**ADC Planning Consultation
Conservation/Design Officer Response**

Application Number	LU/283/17
Address	56 South Terrace, Littlehampton
Description	Unauthorised alteration to the boundary treatment of a Building of Special Character
Case Officer	Lisa Coney
Date	13 September 2017

SOUTH TERRACE ELEVATION

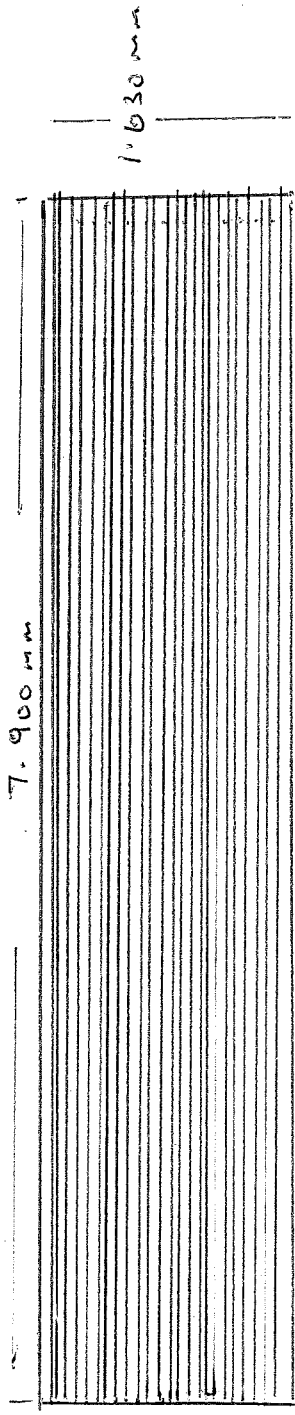
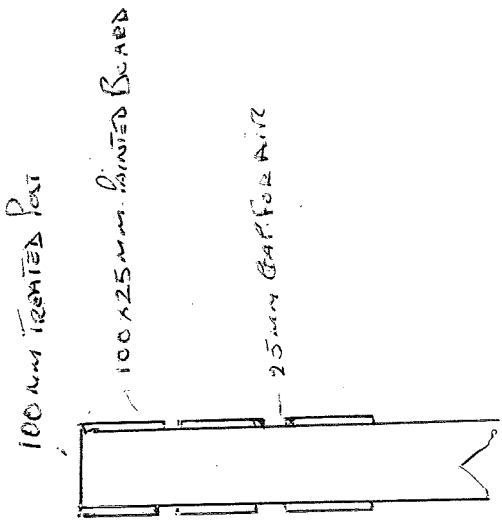
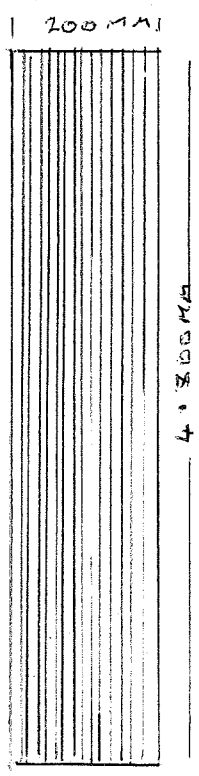
The dwelling is part of a terrace designated as a Building of Special Character and it has a strong presence in the streetscene. The modest gardens in front of the terrace are typically enclosed by a variety of low, visually permeable boundary treatments which allow unobstructed views of the front elevations of the component dwellings. In this context, the introduction of a high, close boarded fence is entirely alien and its presence harms the significance of the locally listed terrace by obscuring views of the principal elevation and cluttering its setting.

The unauthorised fence is contrary to Policy HER DM2, as its alien presence harms the aesthetic quality of the Building Of Special Character and its removal is strongly recommended.
